**Bengalla Coal Mine – Modification 4 (MP 5170 MOD 4)
Statement of Environmental Effects (SEE)**

I refer to your email dated 15 January 2017 inviting the Division of Resources & Geoscience (the Division) to provide comments on the Bengalla Coal Mine – Modification 4 (the Project) Statement of Environmental Effects (SEE) submitted by the Bengalla Mining Company (the Proponent).

FIGURE 2

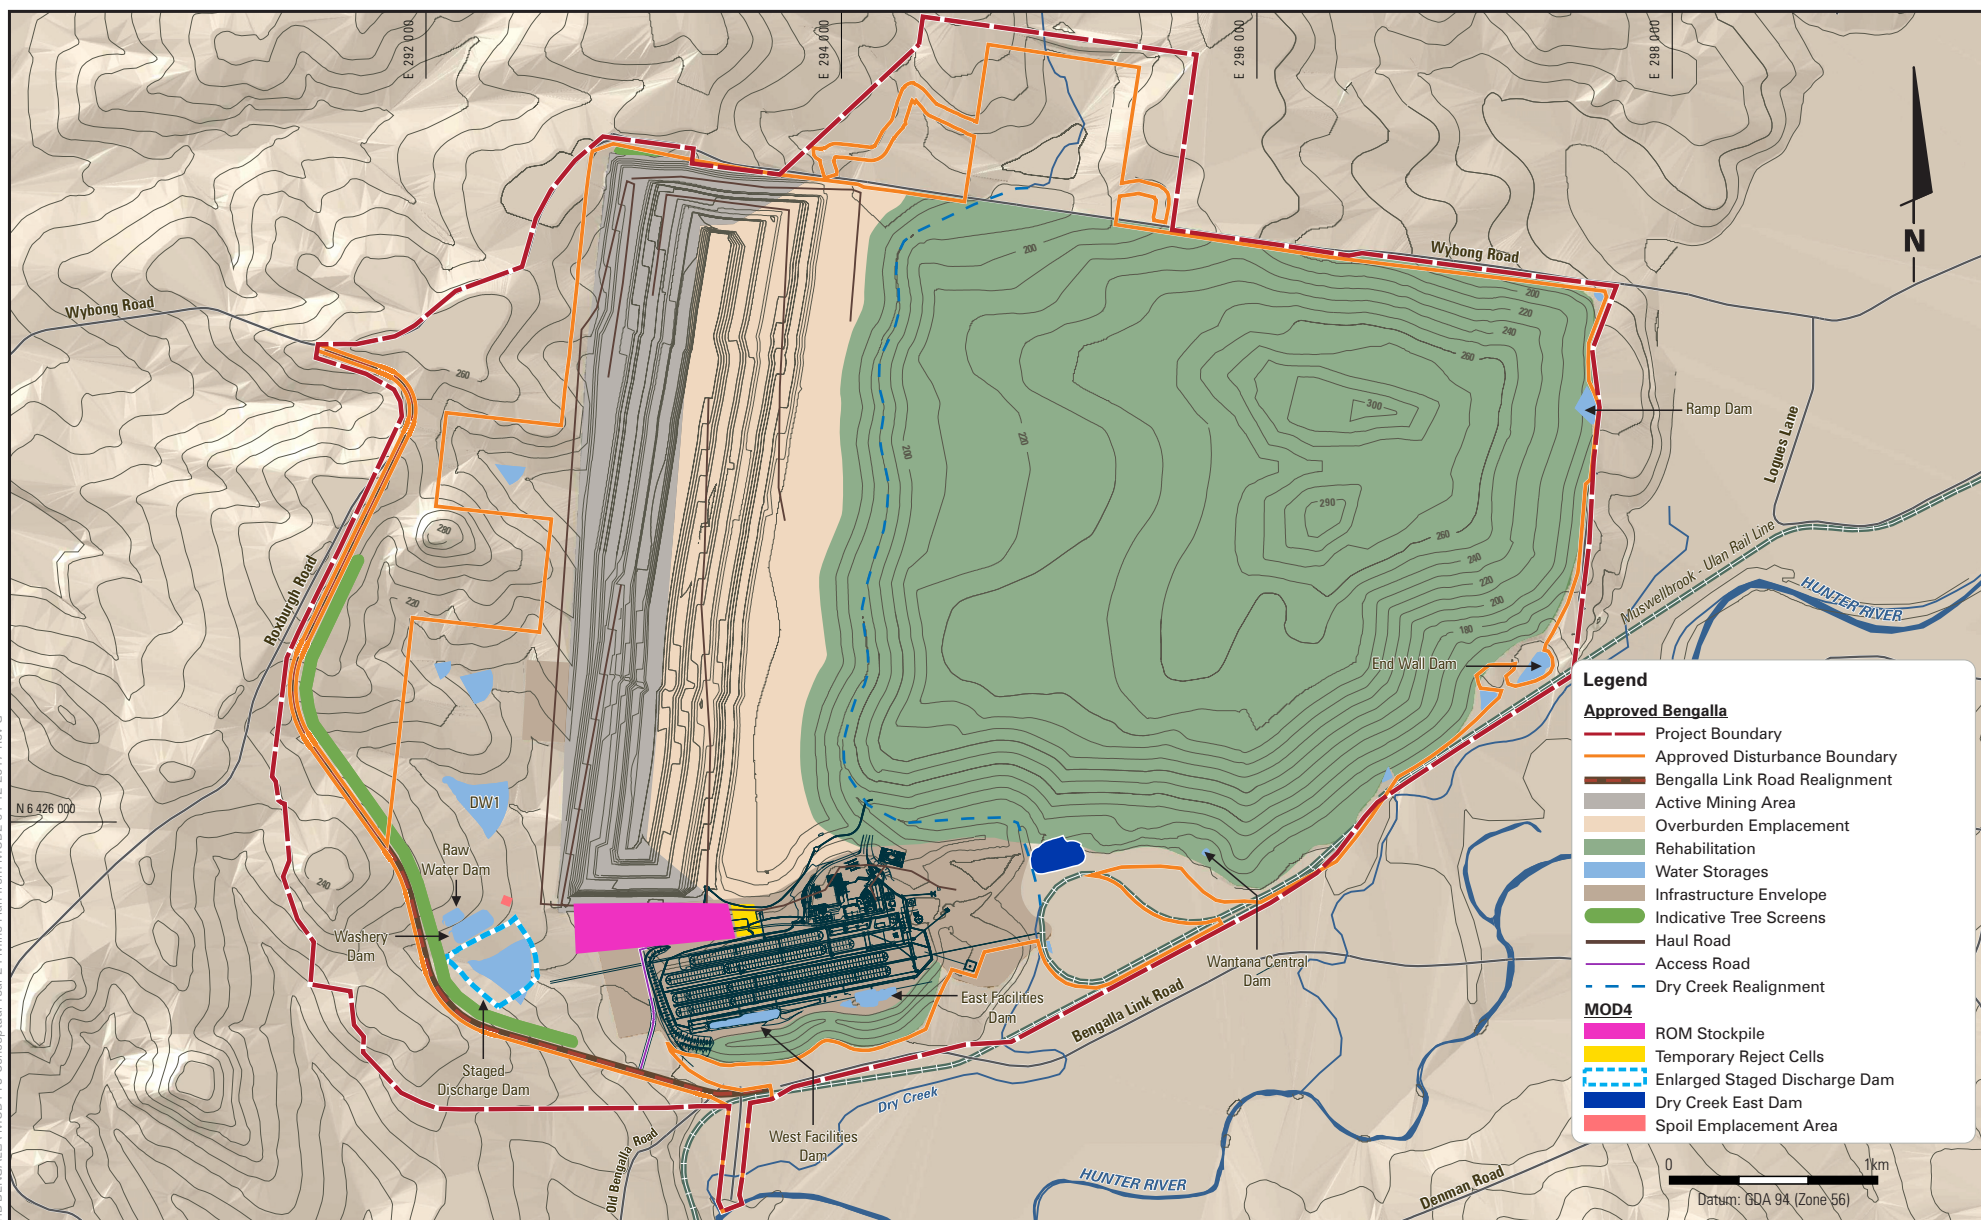
- i. Clarification as to whether the Dry Creek East Dam is to be removed or retained upon mine closure.
- ii. If the Dry Creek East Dam is to be retained in perpetuity, then the following is required:
 - a) Purpose of the dam post mine closure.
 - b) Assurance that the location, design and construction of the dam is suitable for permanent retention.
 - c) Discussion or assessment of the potential environmental impacts of the dam post closure.
- iii. Assurance is required that the enlargement of the Staged Discharge Dam will not impact on its ability to be successfully removed and rehabilitated.
- iv. The proponent is required to provide commentary on the impacts (if any) to the rehabilitation scheduling (both progressive and final rehabilitation) at Bengalla Mine, if the modification is granted.
